Application number: 2026/91628	
What is the application for?:	Erection of 17 dwellings (Use Class C3) together with associated development inc
Address of the site or building:	land off, Boshaw View, Hade Edge, Holmfirth, HD9 2TZ
Postcode:	BD19 5LQ

Application Number 2026/91628

Erection of 17 Dwellings

Land off Boshaw View

Proposed Site Layout

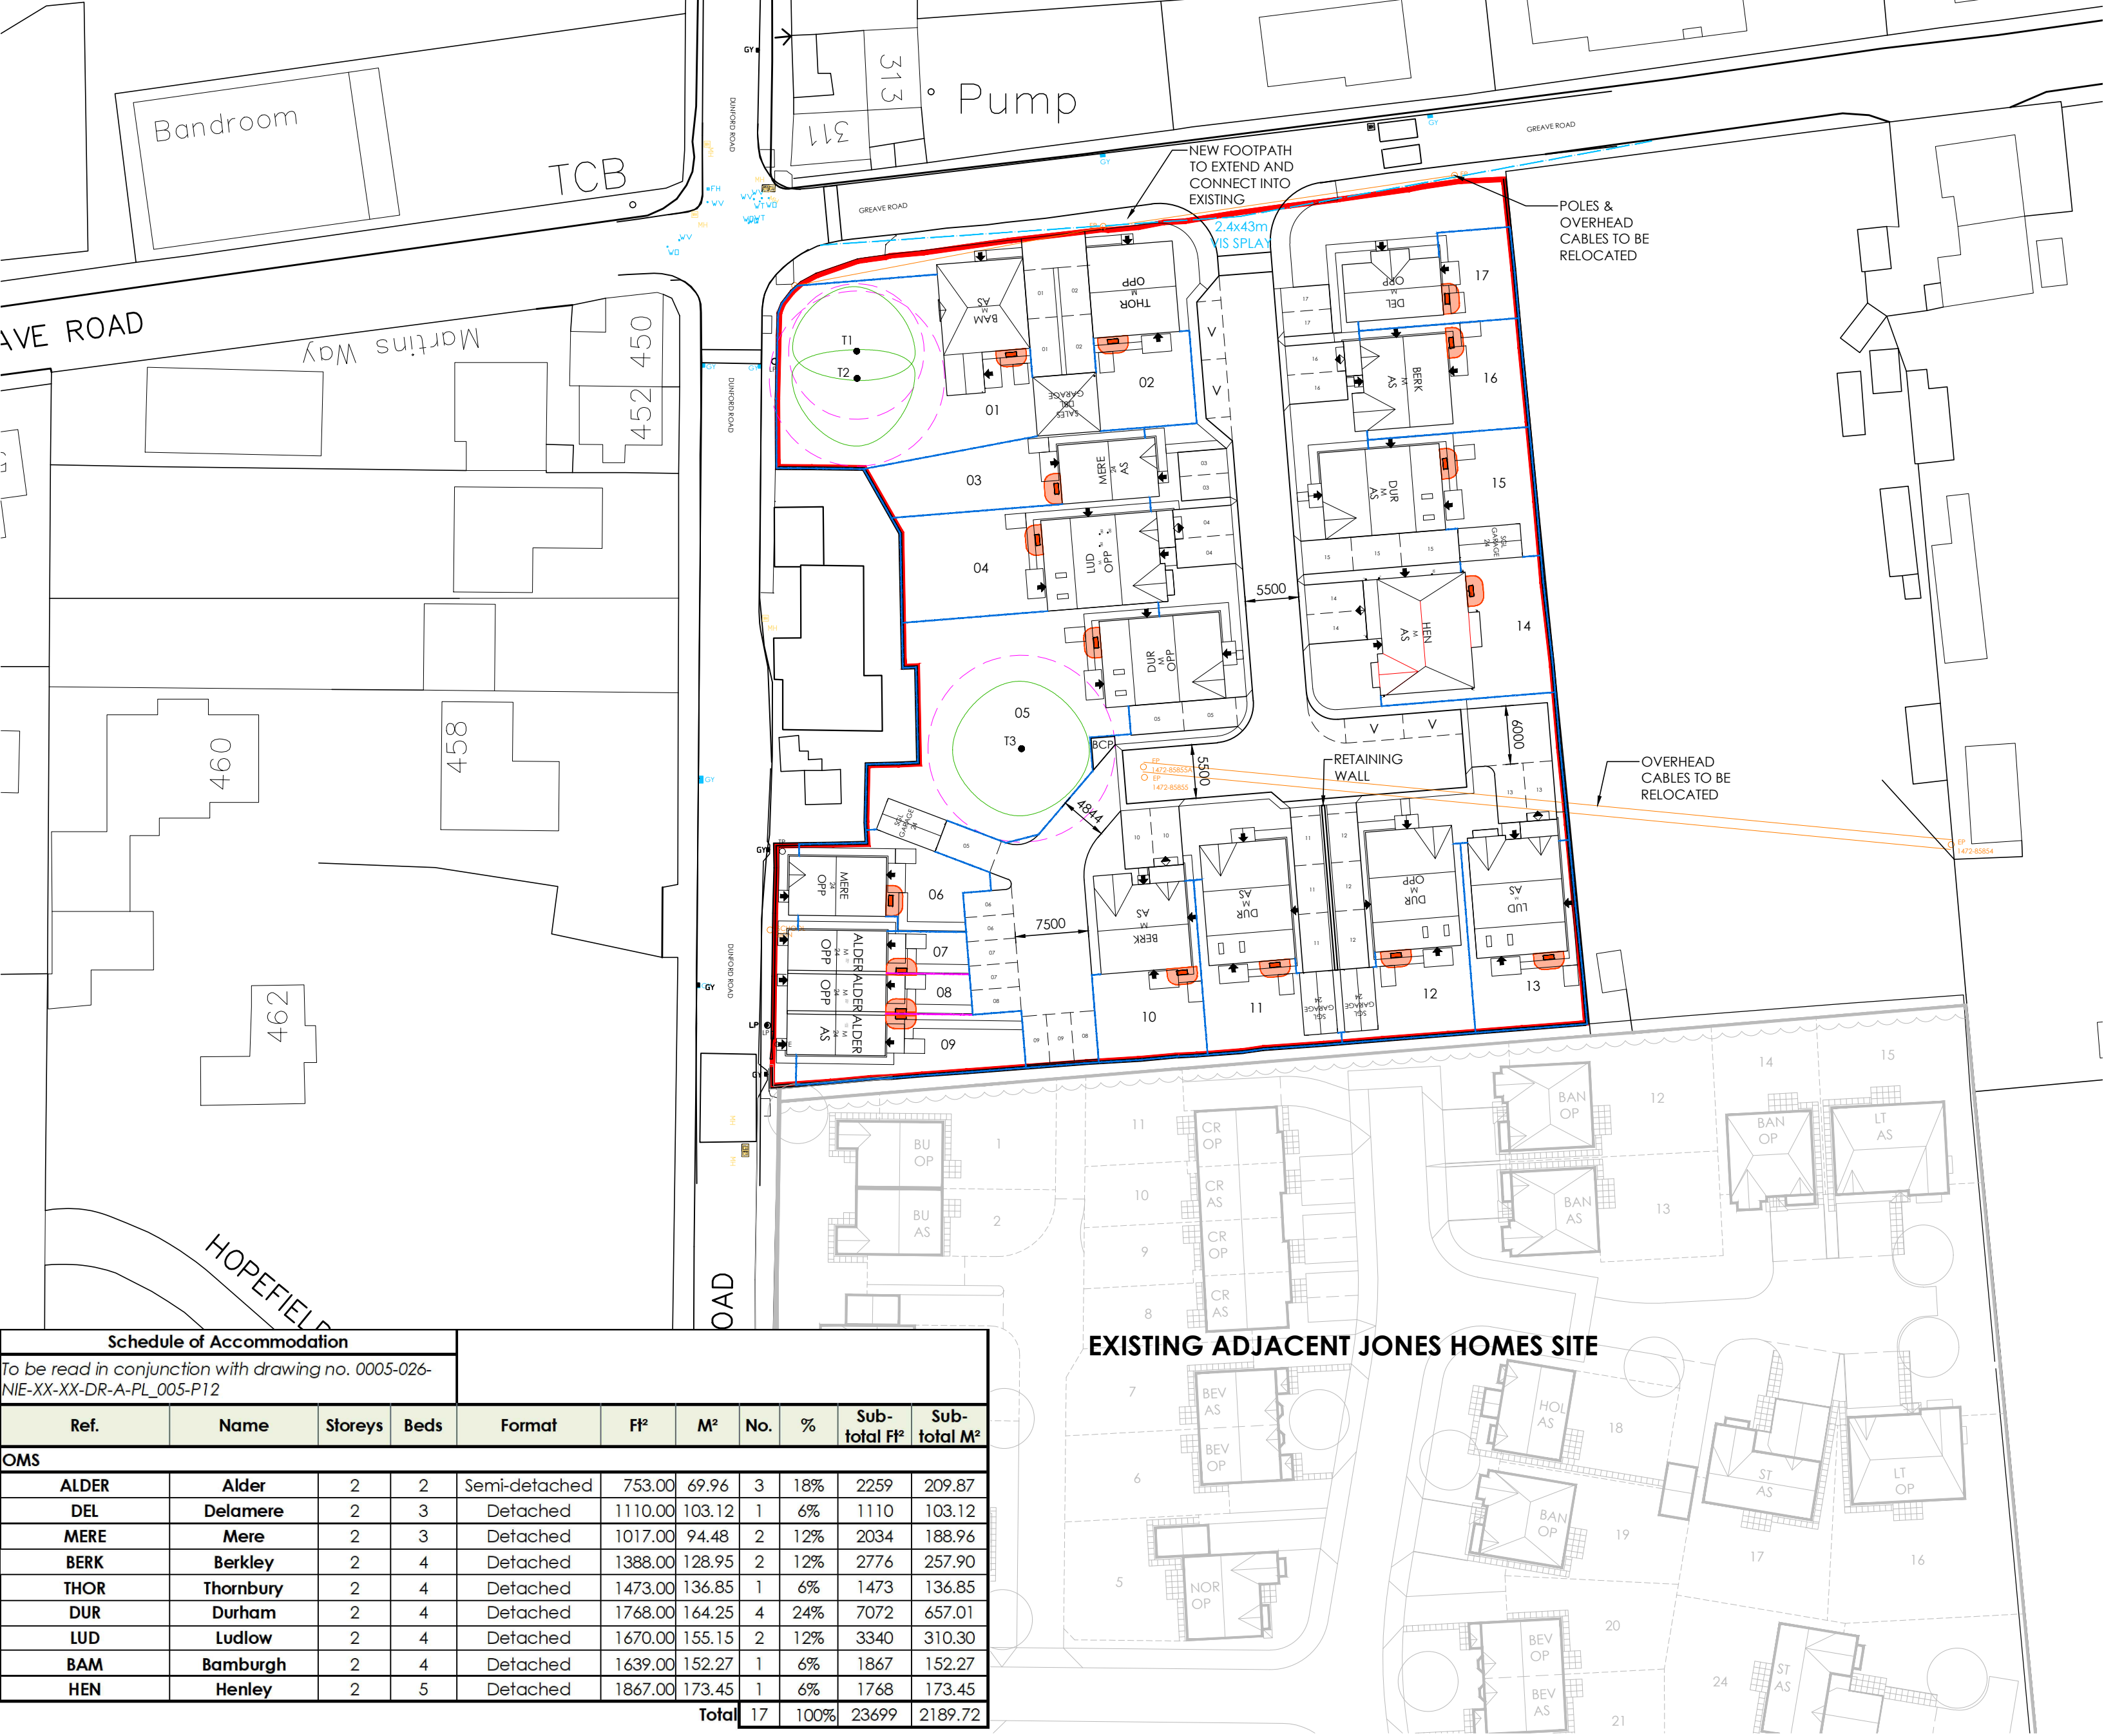
Another grave concern was that the proposed soak away for Plots 01 & 05 are very near the roots of the protected trees 'TPO 14/16', therefore taking away the natural water supply, obviously disturbing the roots during the building process too. I believe strongly this area should be left as an open space. Another case of Jones Homes cramming too many properties in for profit with little concern for our Hade Edge heritage!

Finally, Greave Rd crossroad can be a difficult junction to negotiate when turning left or right onto Dunford Rd. My concern is Jones Homes seem to be erecting a 'Feather Edged Timber Fence 1800mm' on Plot 01, within the boundary wall on their plan. If this is the case it will cause a further obstruction at the crossroads which can be extremely busy during school drop off and pick up times. As well as being totally out of keeping with the area.
